Your Ref: OWPC18168
Our Ref: BE/38/18/RES 21-03-2018
Please ask for:
Ross Leal

Approval of reserved matters following outline consent BE/138/16/OUT for 2 No. dwellings

Land to the rear of 17, 19, 21 & 23 Greencourt Drive Bersted

Client
Matt Lush
Drawing Title
Drainage Layout

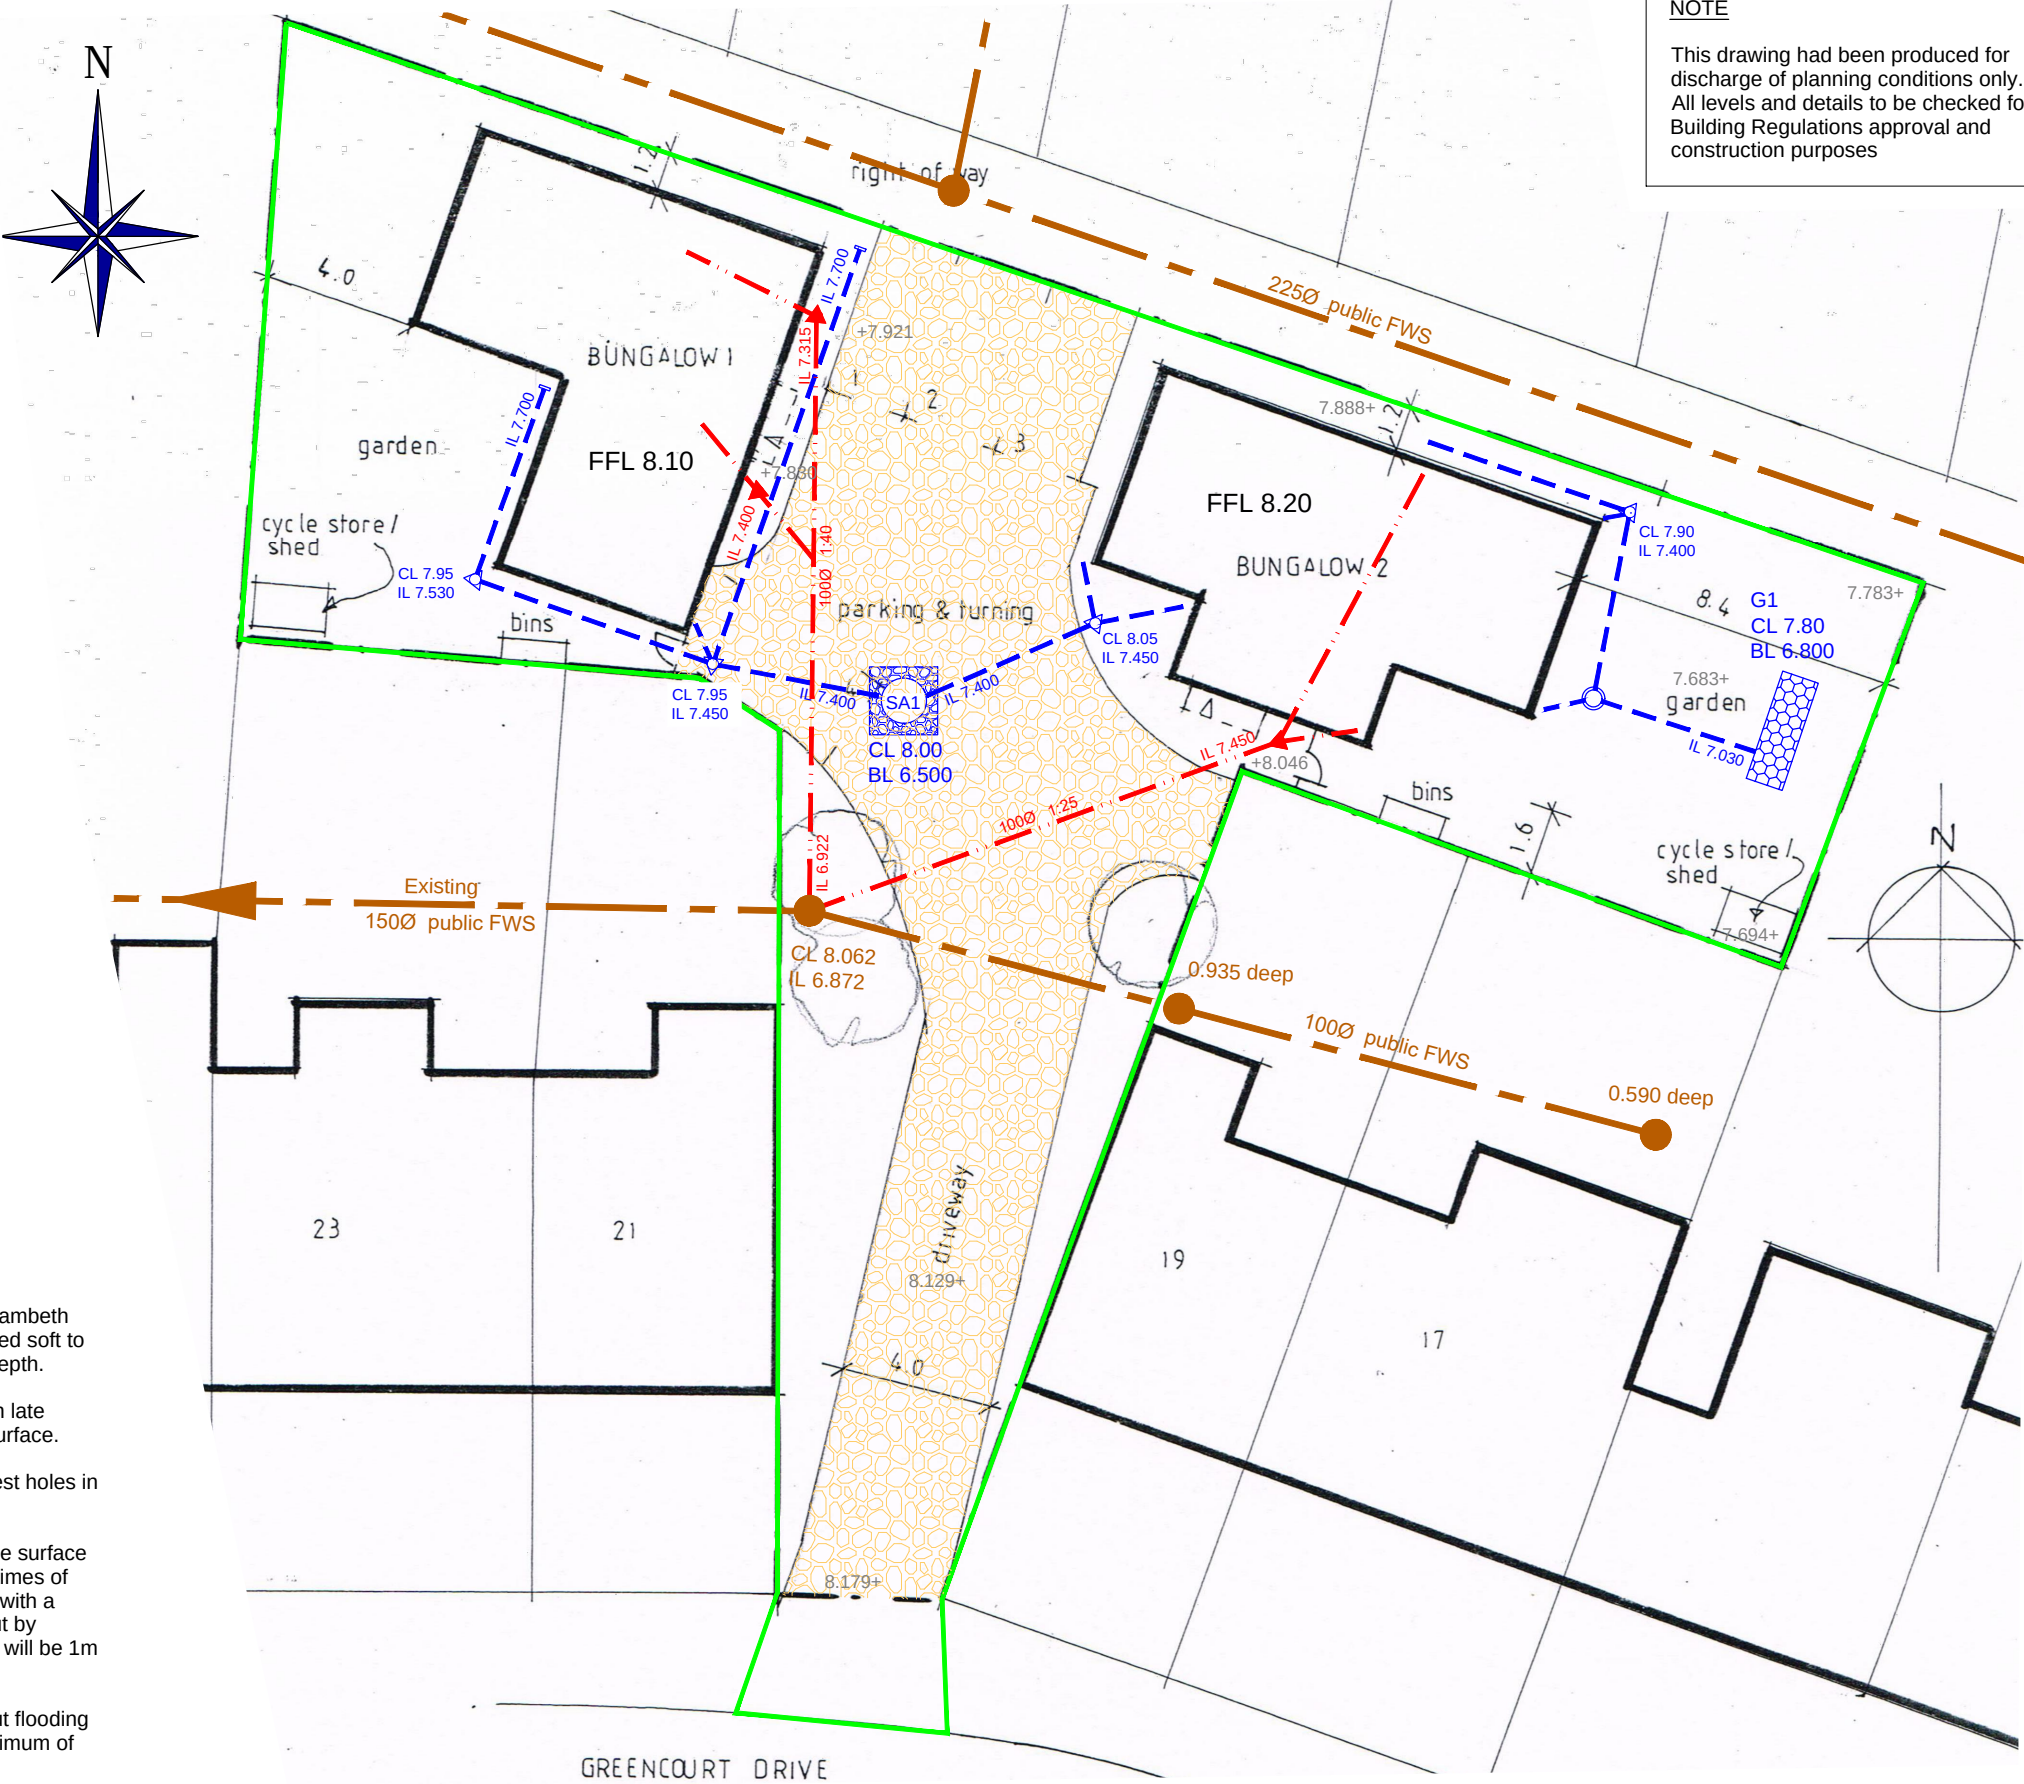
On the matter of drainage for grey water, the plans show these new properties to be connected to public drain serving properties that include my own. As the original design for these drains did not take into account additional properties to be built, will they be able to support the additional waste water. There is also a grey water drain on the plan submitted shown to be outside the property parallel to existing public access path. I would question its location as there is a man hole serving this drain within my own boundary. Therefore assume it to be within boundary of land behind 17-23 as well. Any new builds may be on top of this drain.

Roof plan
SCALE 1:100 AT A3

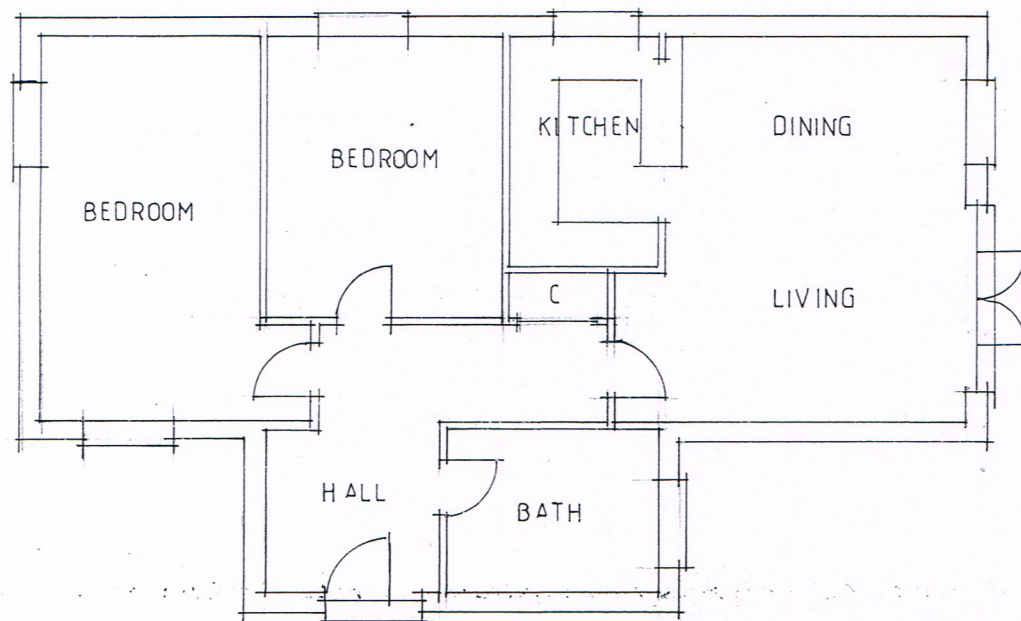
The appeal has approved proposal to build on this site. While people quote policy as a beneficial reason to build, those same policies do not serve to benefit the interest of the people who have to live with them. While it may well be in some eyes not visible from main road, it will always be visible to those who live in the adjoining properties. Are you able to confirm these are two single story dwellings. Plans are for two bungalows but there are no dimensions to indicate height at roof top. If these properties are to be built then angle of pitch on roof should be shallow enough to reduce visible impact and prevent further extension.
